CITY OF PORTLAND

August 26, 1996

RE: One Portland Square

Your application to make renovations to the 6th floor, GSA space, has been reviewed and a permit is herewith issued subject to the requirements listed below. This permit does not excuse the applicant from meeting applicable State and Federal laws.

SOCIAL SECURITY HEARING OFFICE  
FLOOR 6 PORTLAND SQUARE 1

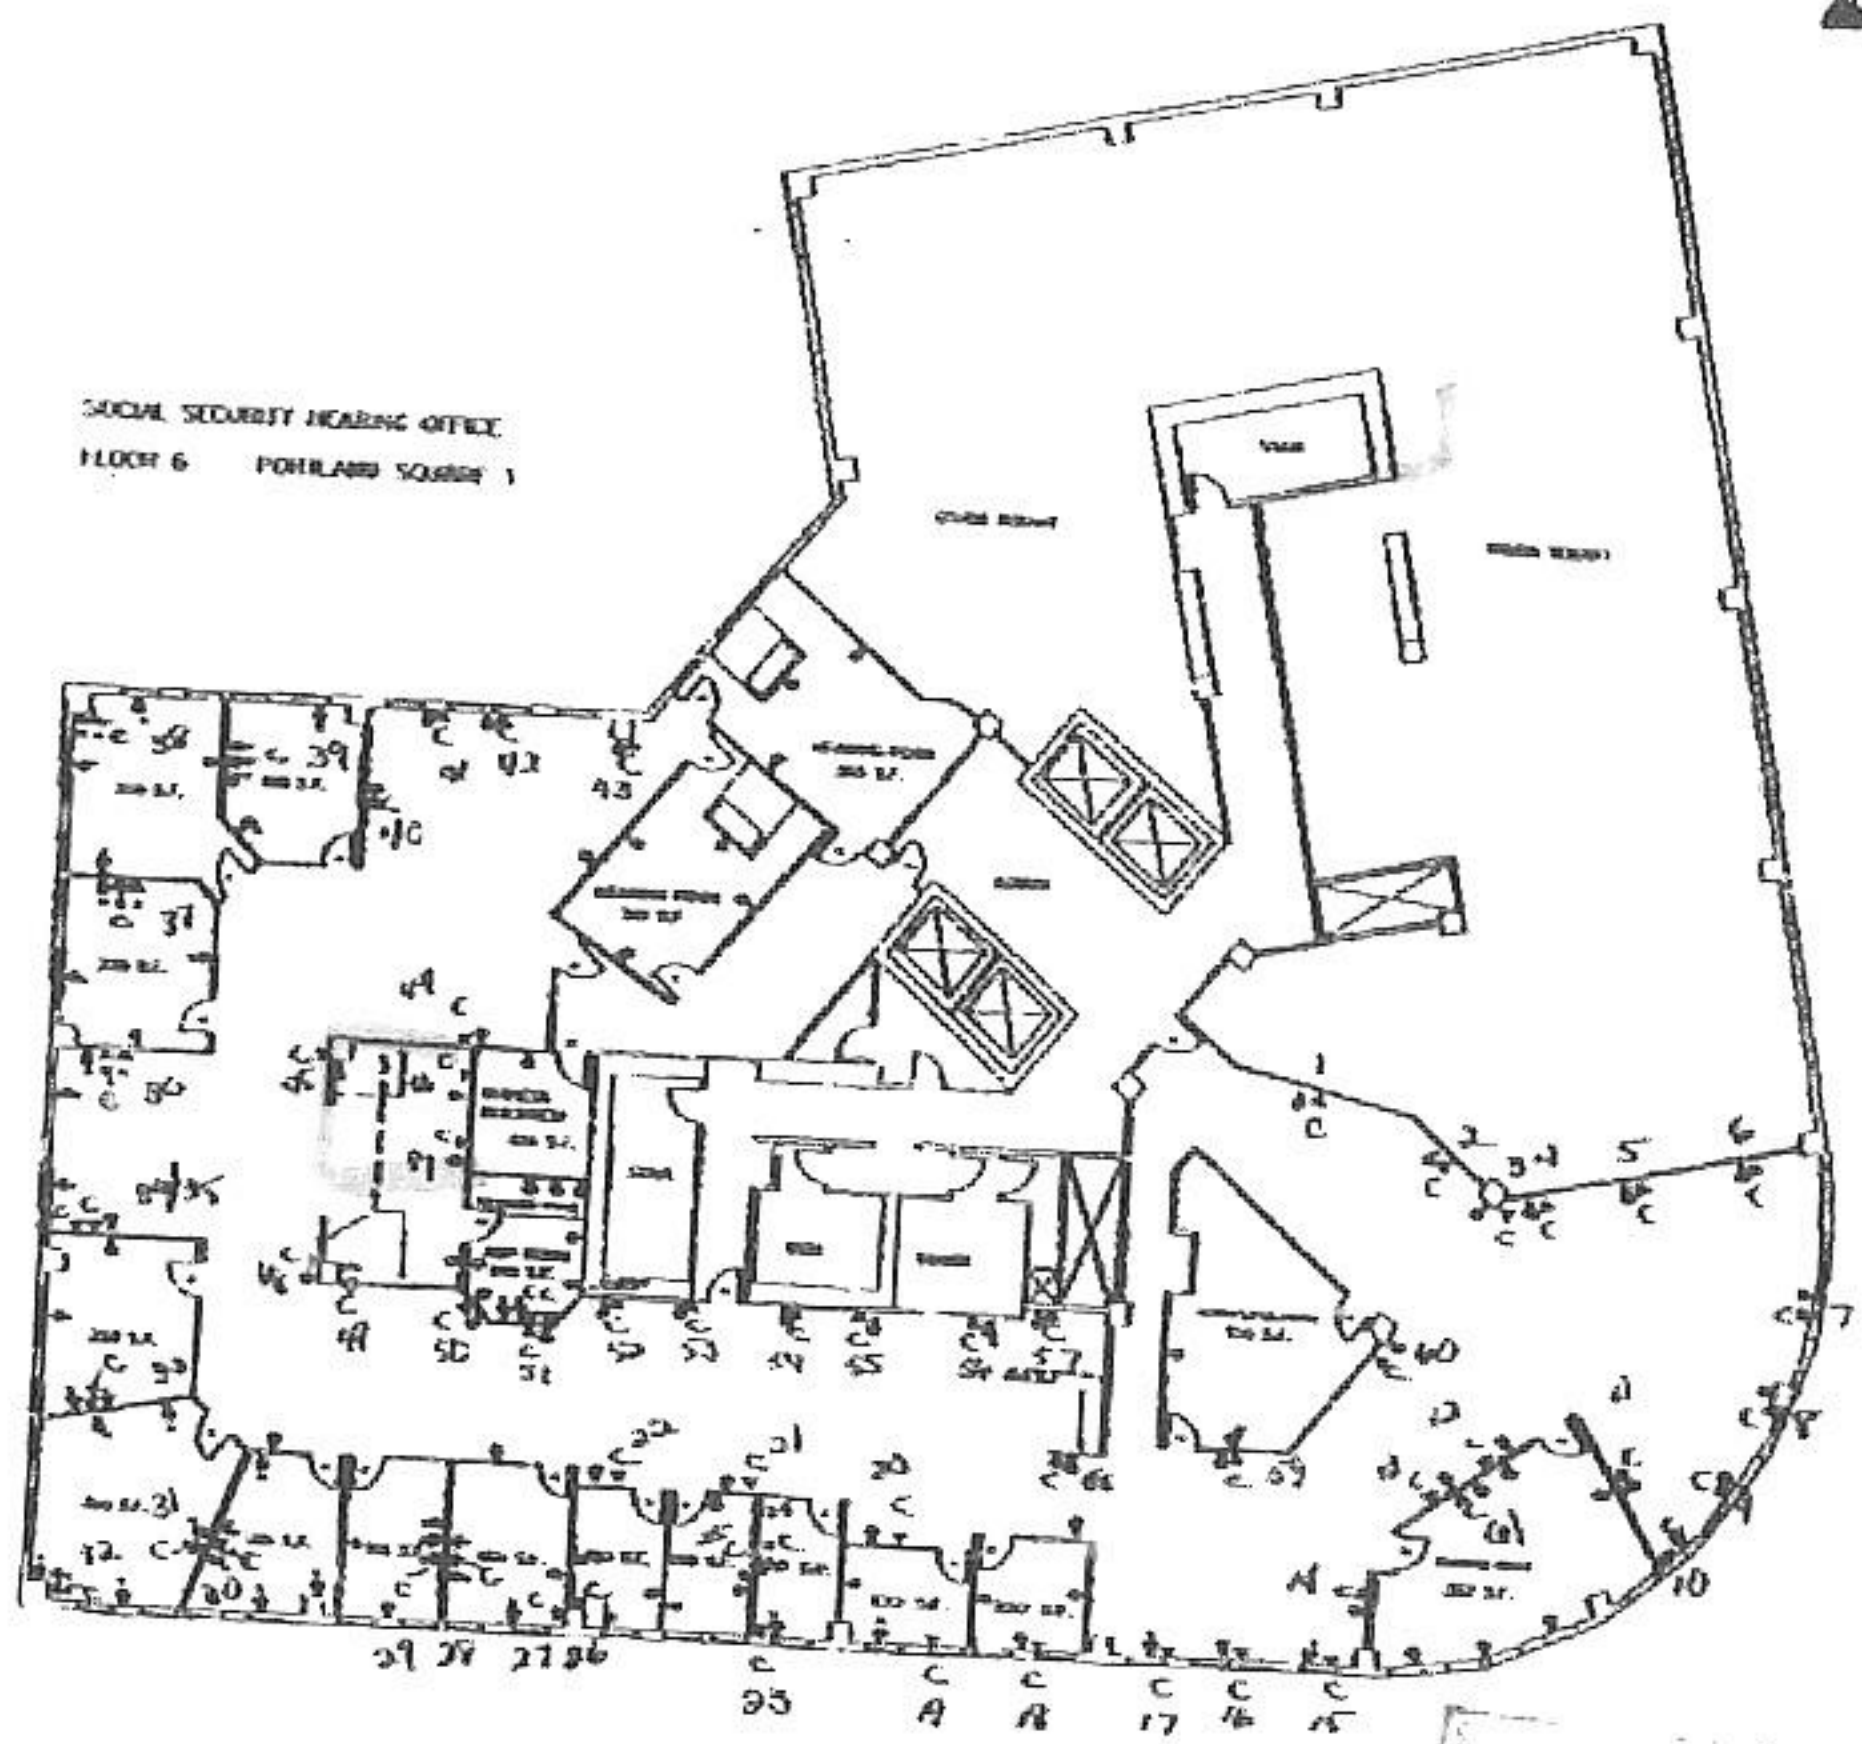
1. The stairways shall be maintained with a two hour enclosure.
2. All exit signs, lights and means of egress lighting shall be done in accordance with Chapter 10 of the 1996 BOCA Building Code and NFPA 101 Fire Prevention Code.
